Please ask for: Mrs D Johnson
Email: daun.johnson@arun.gov.uk
Telephone: 01903 737762
Our Ref: Y/152/20/RES
Your Ref:
Date: 12th January 2021

Application for Approval of Reserved Matters Following Outline Approval

Development: Approval of reserved matters (appearance, landscaping, layout and scale) following the grant of Y/91/17/OUT for 250 No. dwellings with associated parking, road/footway/ cycleway provision, open space, landscaping, surface water attenuation & ancillary works.

Location: Land At Bilsham Road Yapton

CLIENT:	Bilsham Road Development LLP	PROJECT:	Bilsham Road Yapton
SCALE:	1:100 (A1 ORIGINAL)	DRAWING:	C3H10 - Semi Full Plans & Elevations
DRAWN:	RDB/SA	19284	P127
DATE:	01/09/20		A

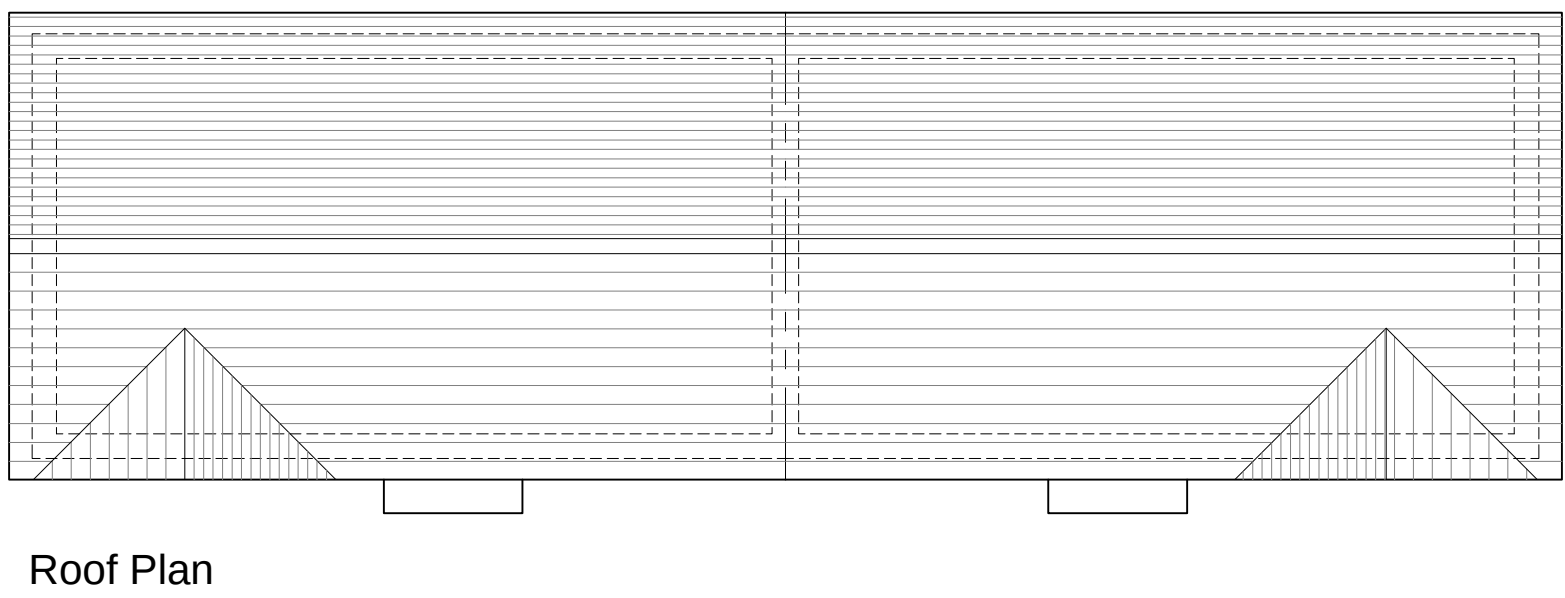
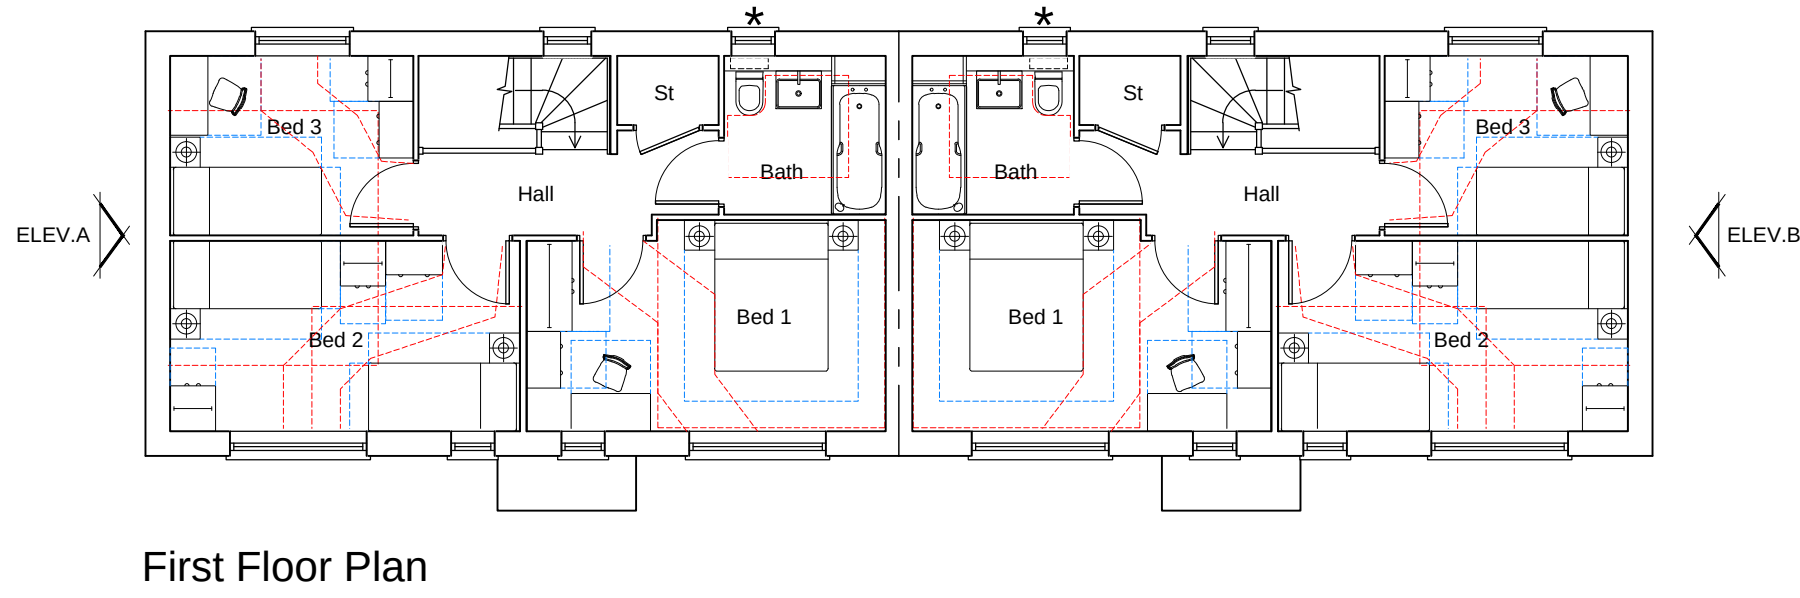
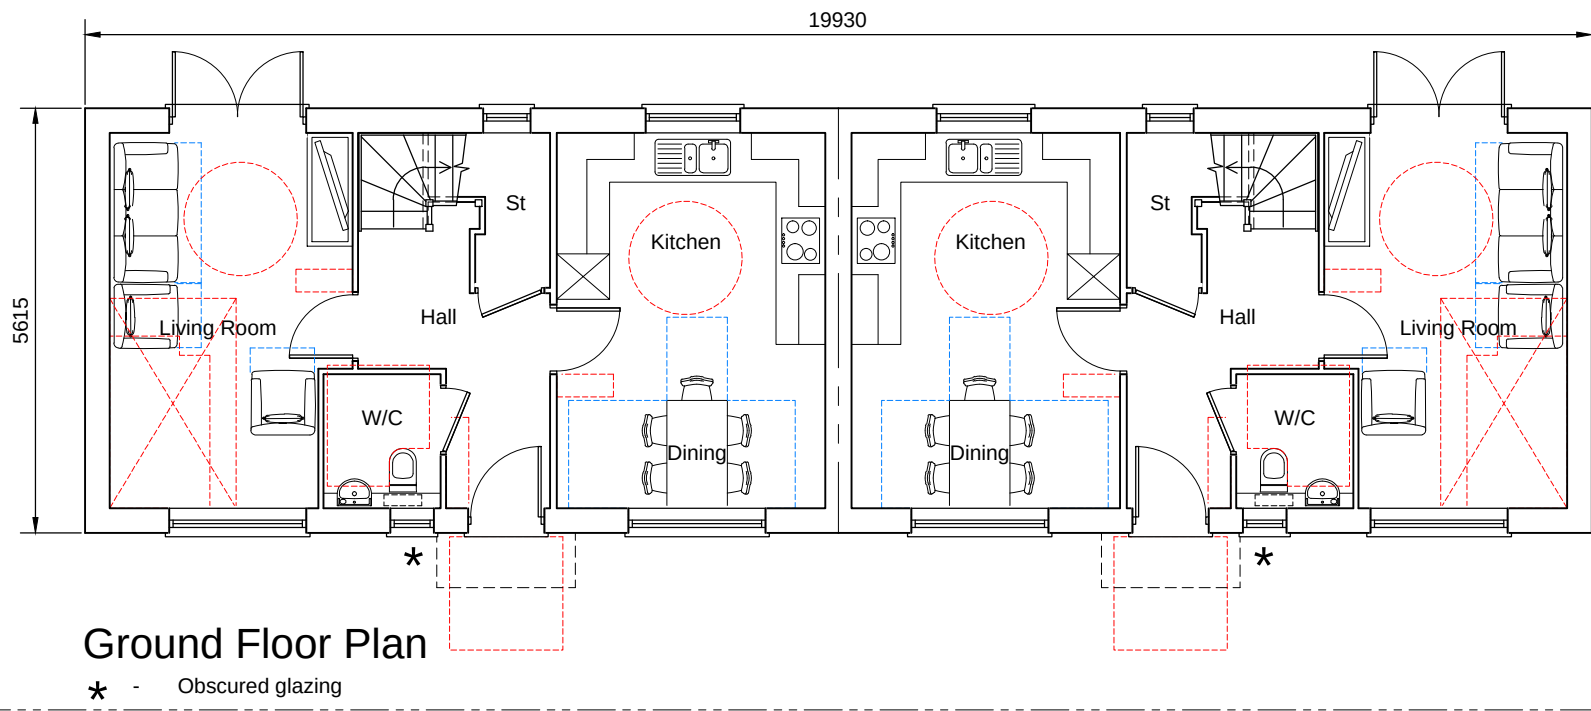
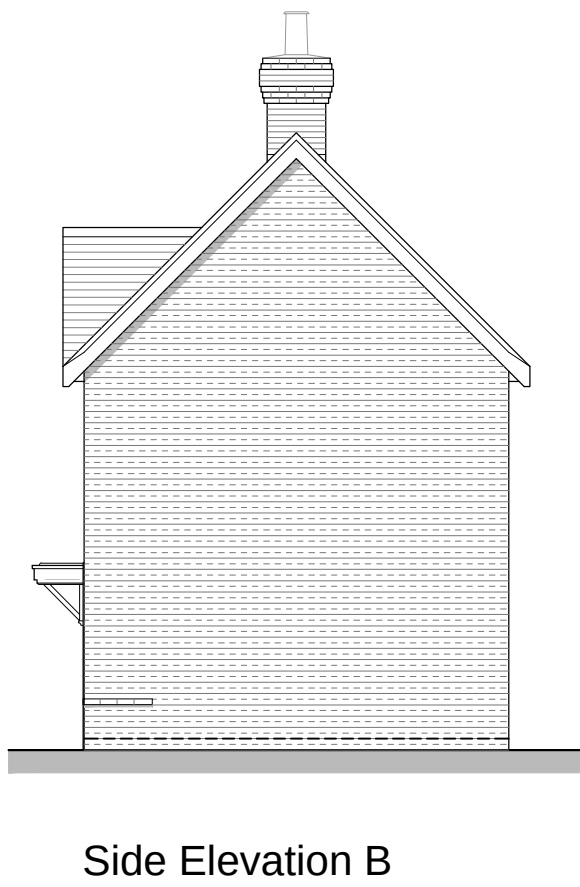
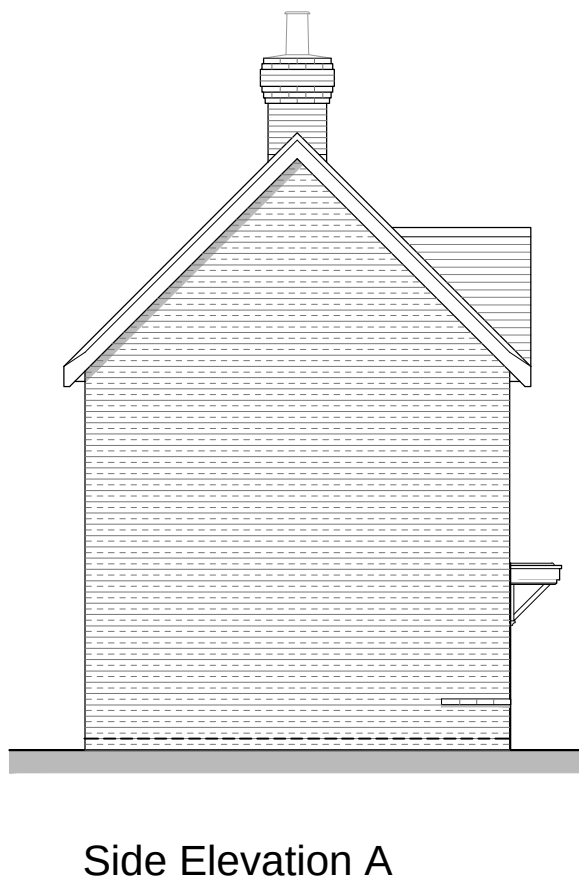
On Plan P127 the ground floor plan and rear elevations do not accord. Please amend accordingly.
